**Consultation Response from KC,
Highways Development Management**

2026/90929 adj, 60, Cowrakes Road, Oakes, Huddersfield, HD3 3ST

Demolition of existing garages and erection of leisure annex with associated external alterations

Plan ref: 2968_(100)03 rev A Proposed Site / Block Layout

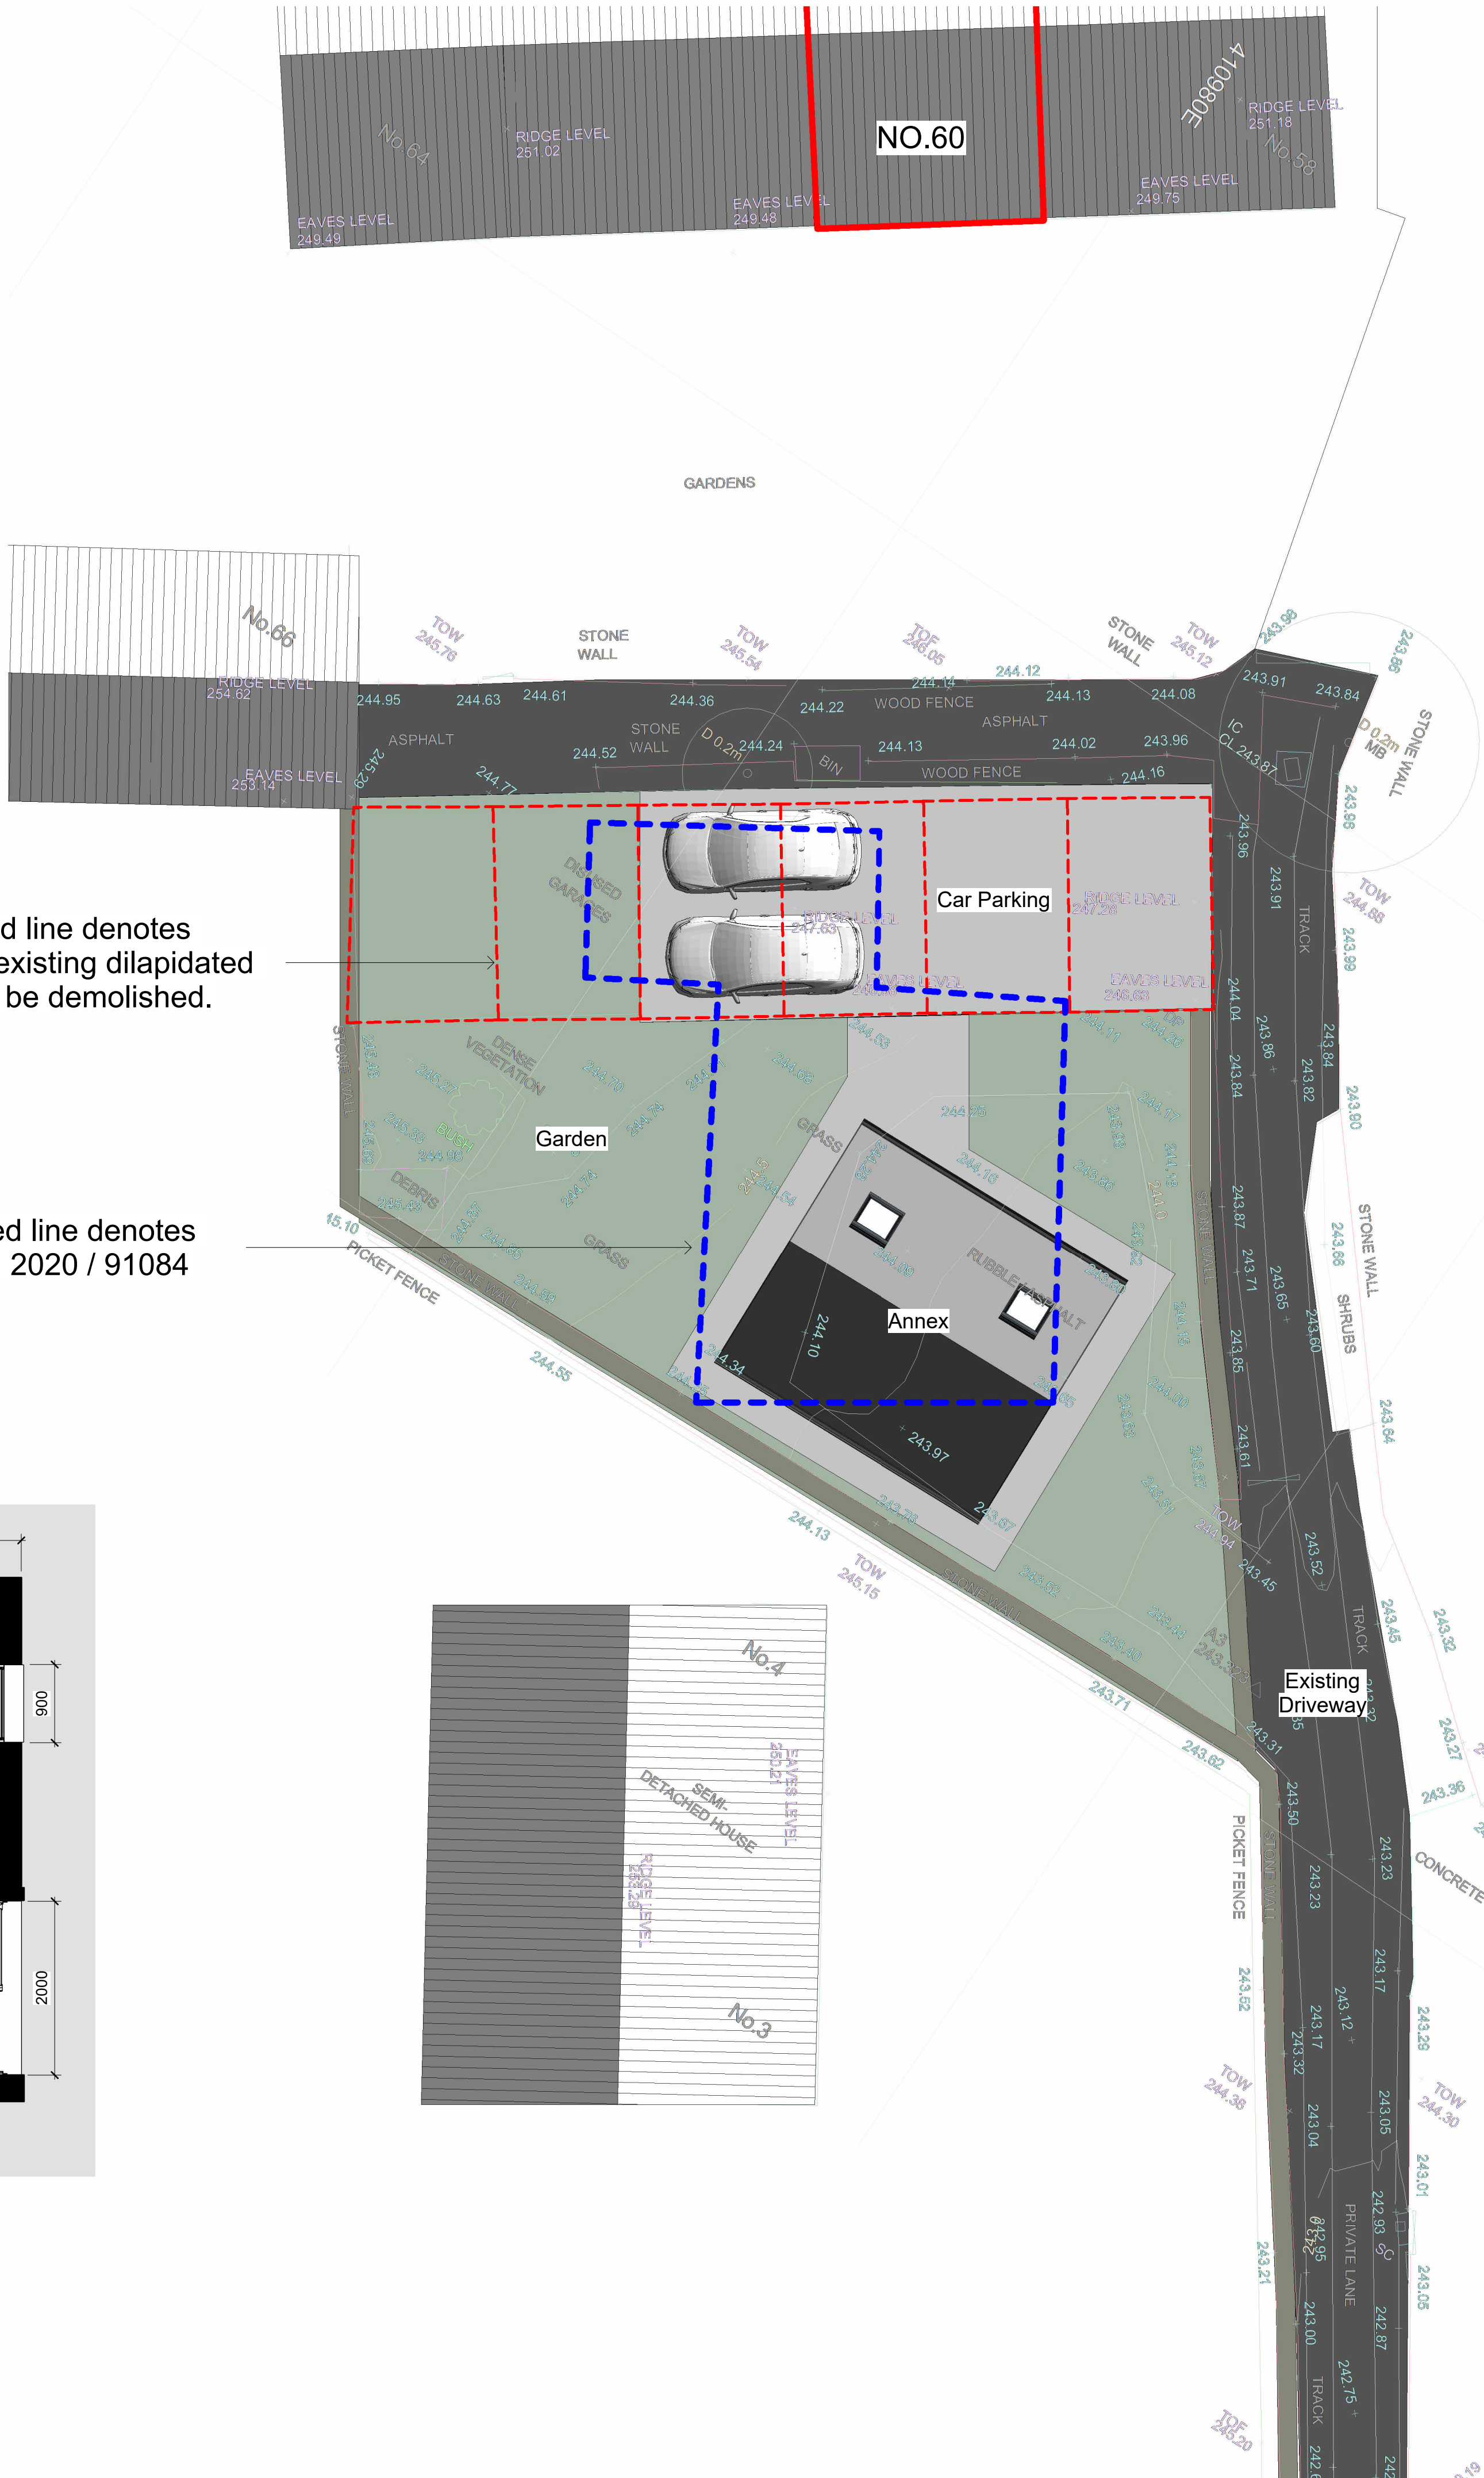
The existing access is retained from the unadopted unmade lane shared with neighbours from Cowrakes Road. Whilst this is narrow by current standards and benefit from resurfacing, weight is given, and accepted previously under planning approval 2020/91084, that the demolition of the existing six garages represents a de-intensification. Additionally, the usage is of long standing and would be like the outline consent for one dwelling even if there is occasional use of the leisure annex for overnight accommodation.

The proposed area of hard surfacing is of adequate size to allow for parking and turning with two car parking spaces to be provided. These elements are sufficient. The amount of parking would meet advice set out in the Kirklees Highway Design Guide SPD too and be in line with policy LP22 with there being space for flexible arrangements, including visitor parking space. The hardstanding should be of a permeable surface material.
